RFI

RFI #: 205
Date: 11/9/2012
Job: EB-02 Keller Springs Lofts
Phone: 877-777-5115

Subject: B windows in the upperfloors of the public areas

SHEET NUMBER  
**3.3D**

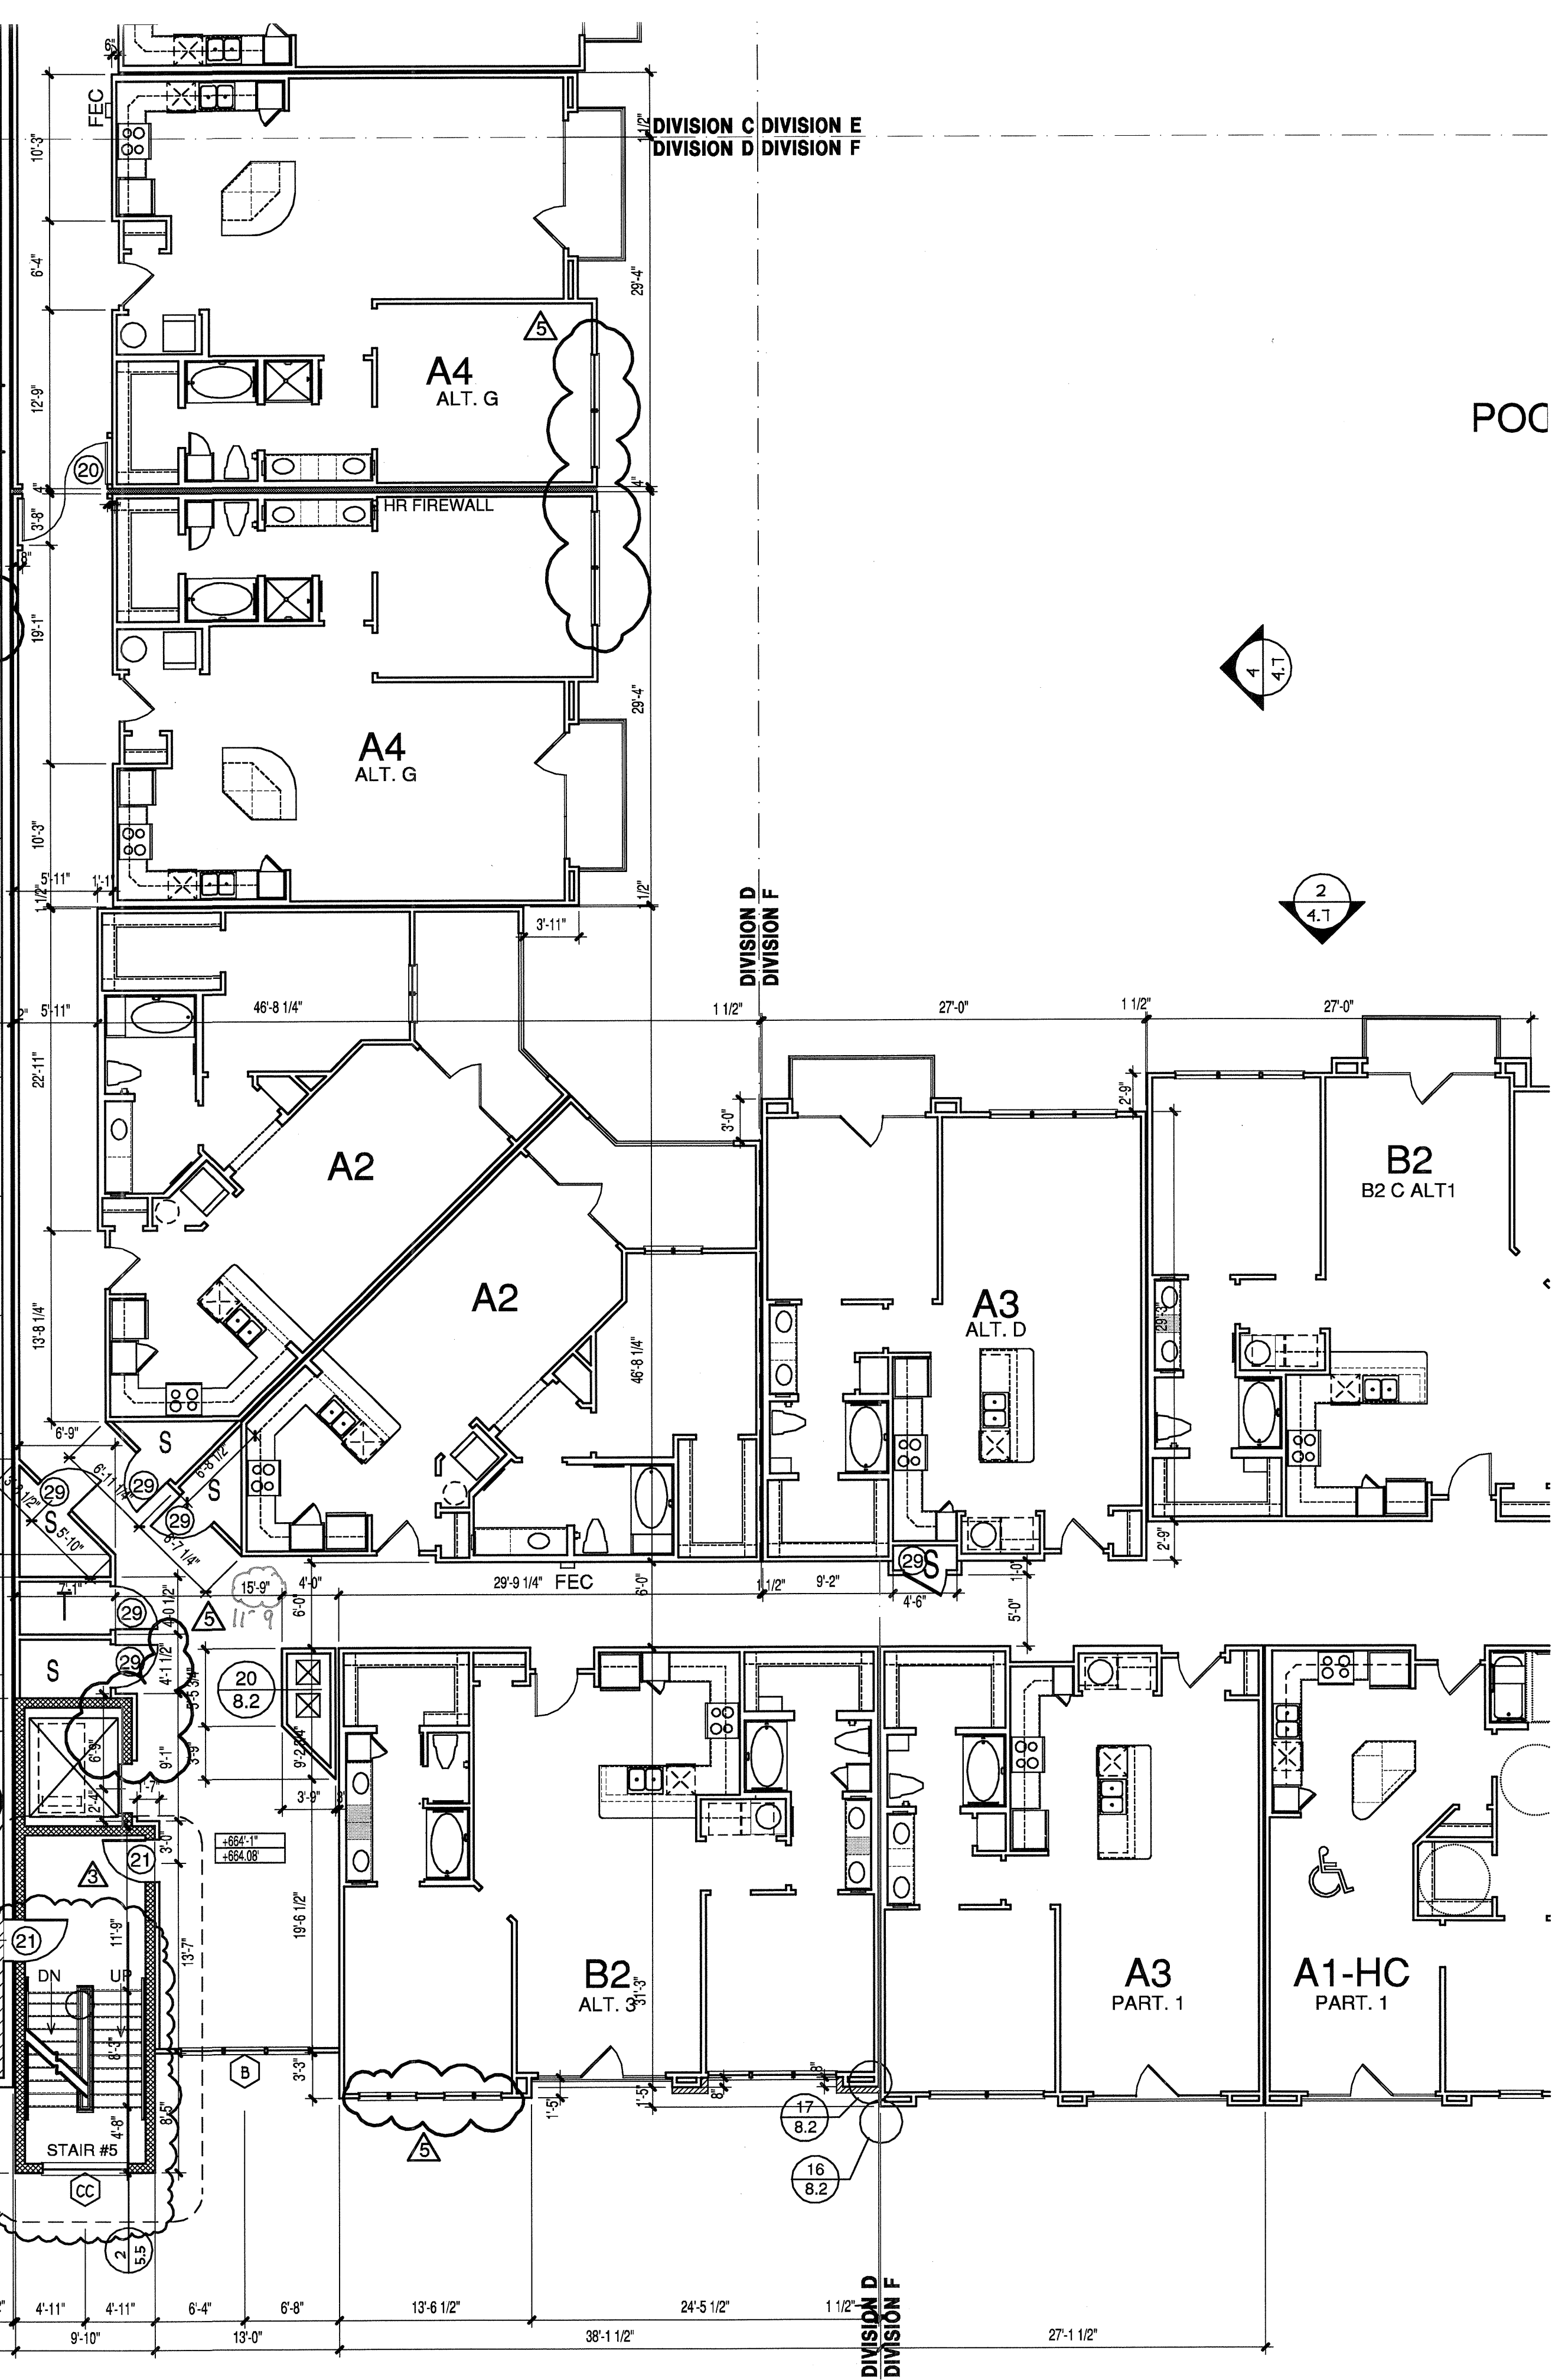
Request: **Date Required:** 11/16/2012
There are (6) B windows in the upper floors of the public corridor shown on sheets 3.2B, 3.3B, 3.4B, 3.2D, 3.3D, & 3.4D. Since these windows are in a public area shouldn't they be fixed windows & not operable windows?
Requested by: Bryan Pickler
Embrey Partners, Ltd.

Response:
The window sizes are correct, and yes, these should be fixed, non-operable windows.
